CITY OF ALBUQUERQUE

August 10, 2017

RE: **GGP Seritage JV Redevelopment**
6600 Menaul Blvd NE, Suite 5000
Request for Certificate of Occupancy – Permanent
Hydrology Final Inspection – Not Accepted
Engineer's Stamp Date 7/8/16 (H18D005F)
Certification Dated: 7/7/17

SHEET NUMBER  
CIVIL 004

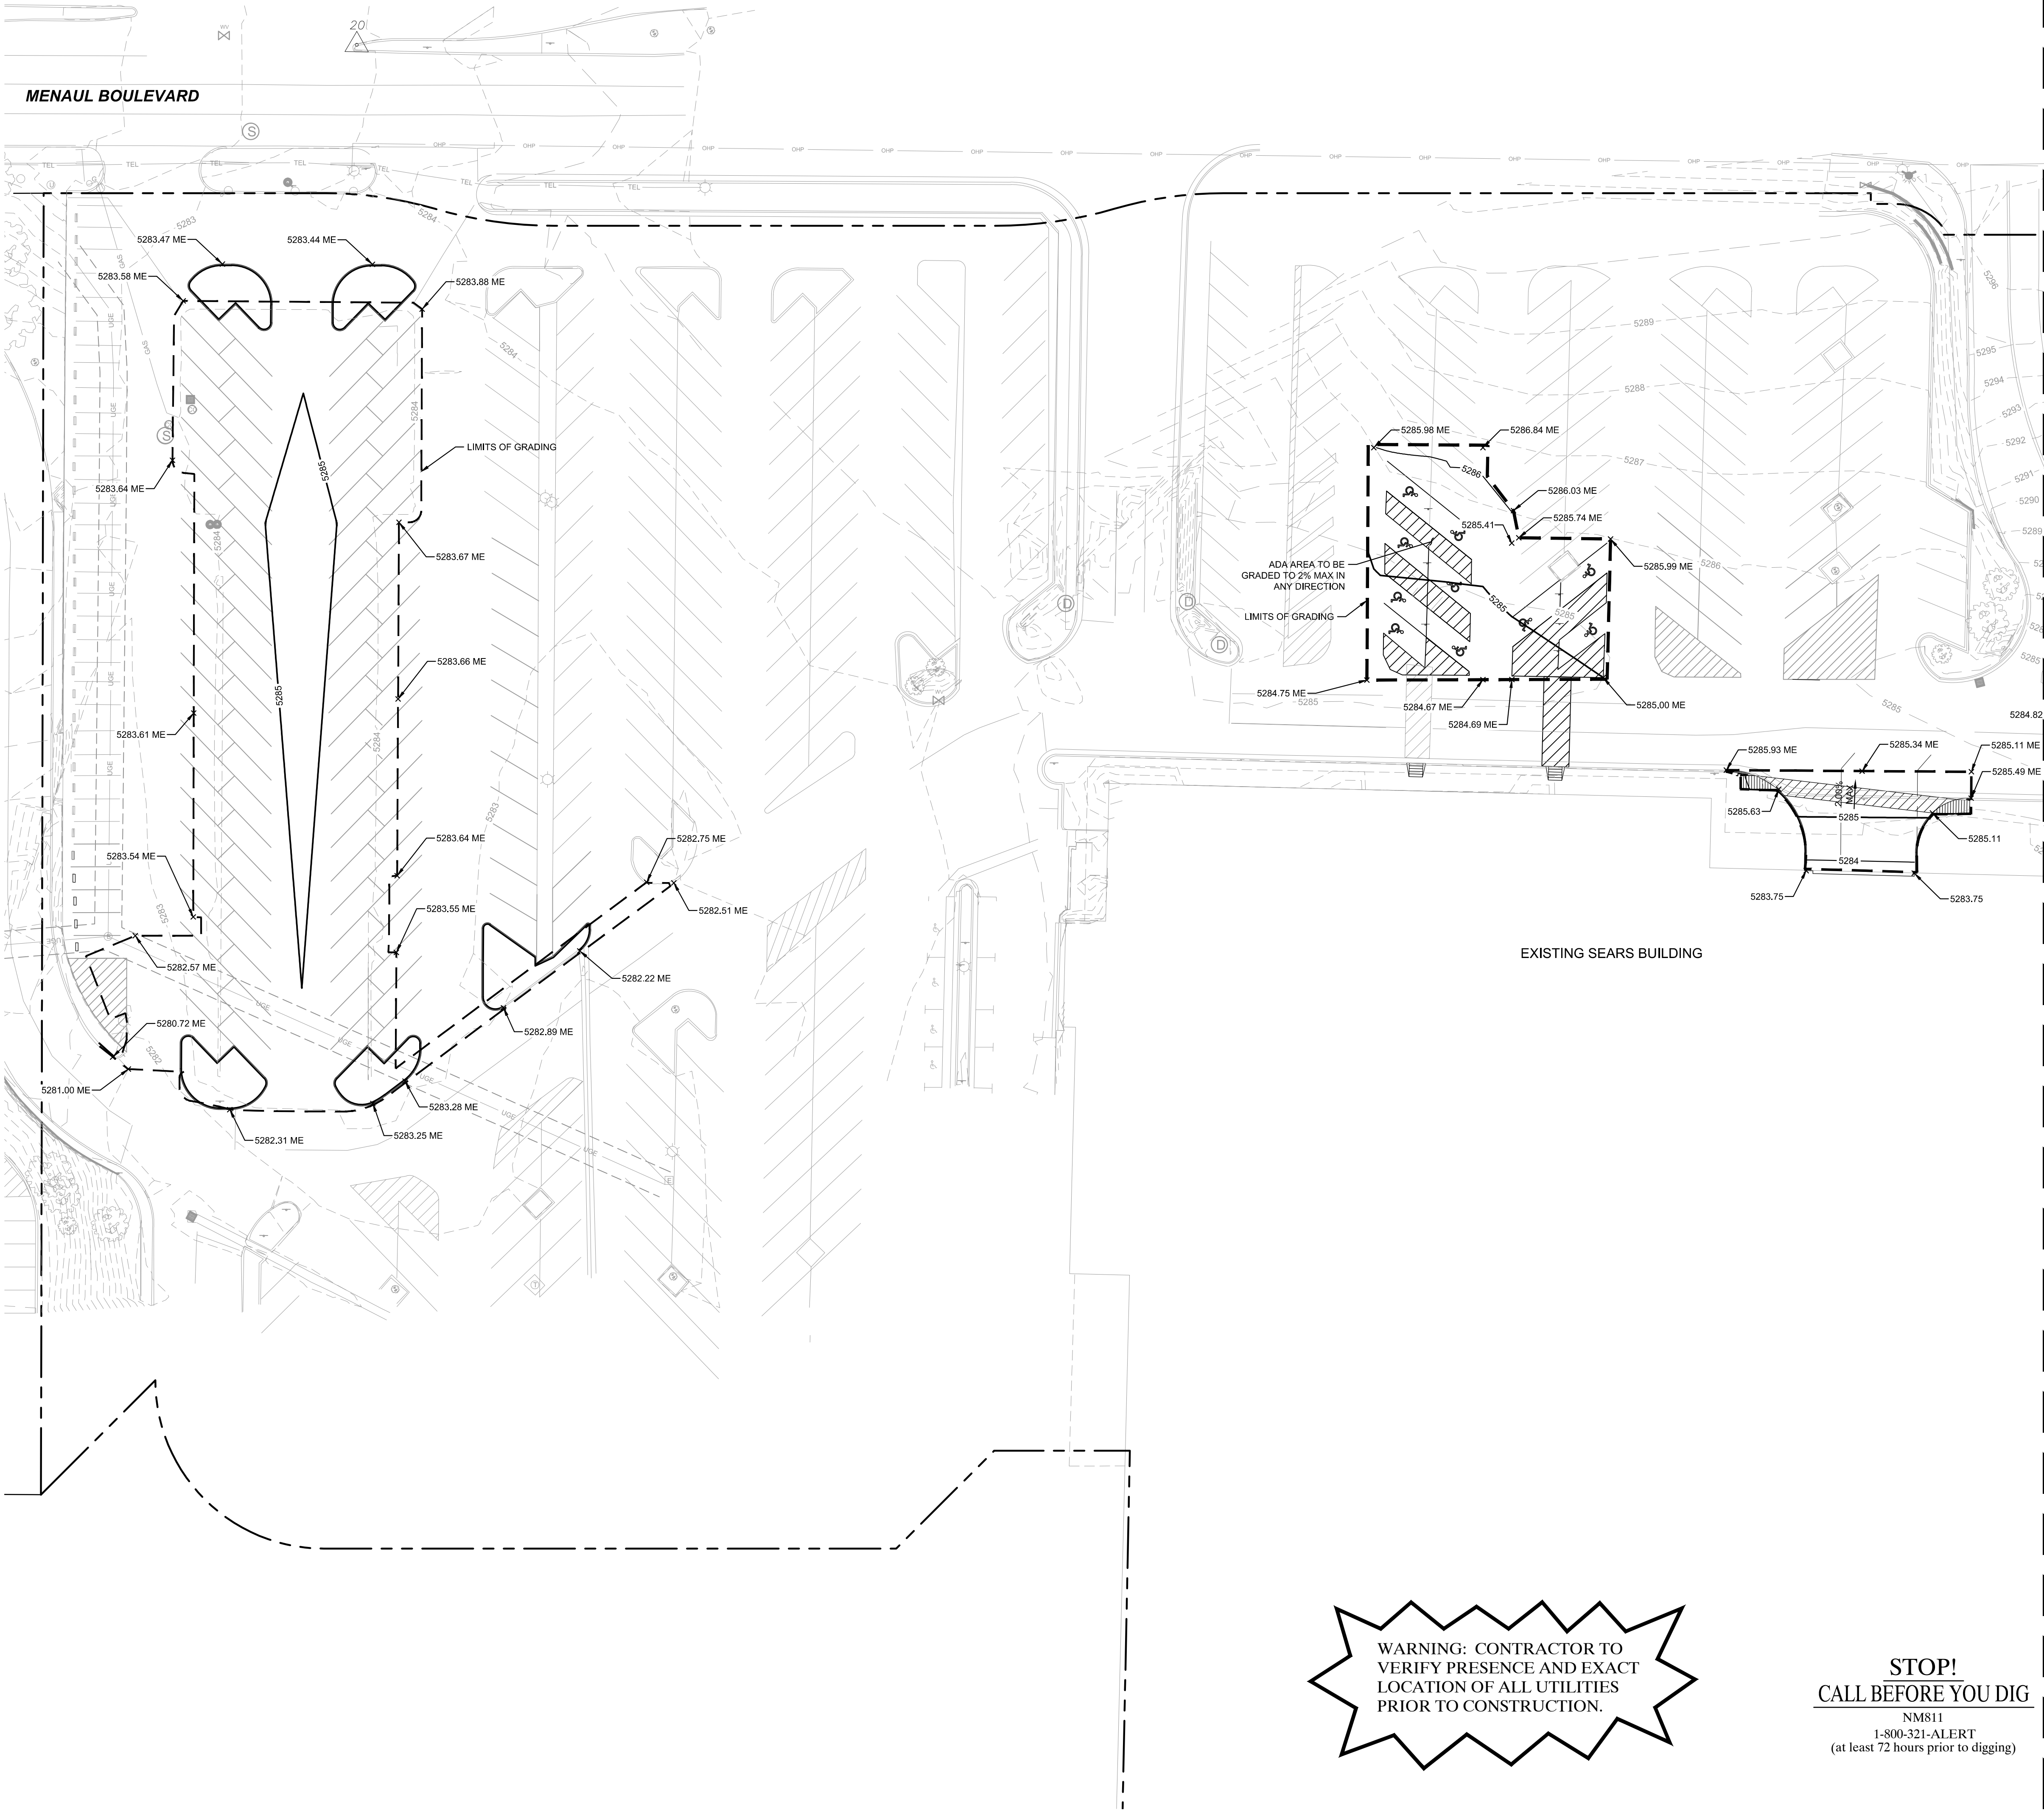
1. The submittal is incomplete; the entire grading plan (C004 & C005) needs to be as-built and certified; only the as-built of sheet Civil 004 was received.
2. The engineer's stamp date and signature in the title block need to match the original approved grading plan (7/8/16). Only the Drainage Certification statement should have the more recent date, certifying the work as-constructed.
3. Informational: Traffic submittals should be sent in separately, as they are reviewed by different engineers.
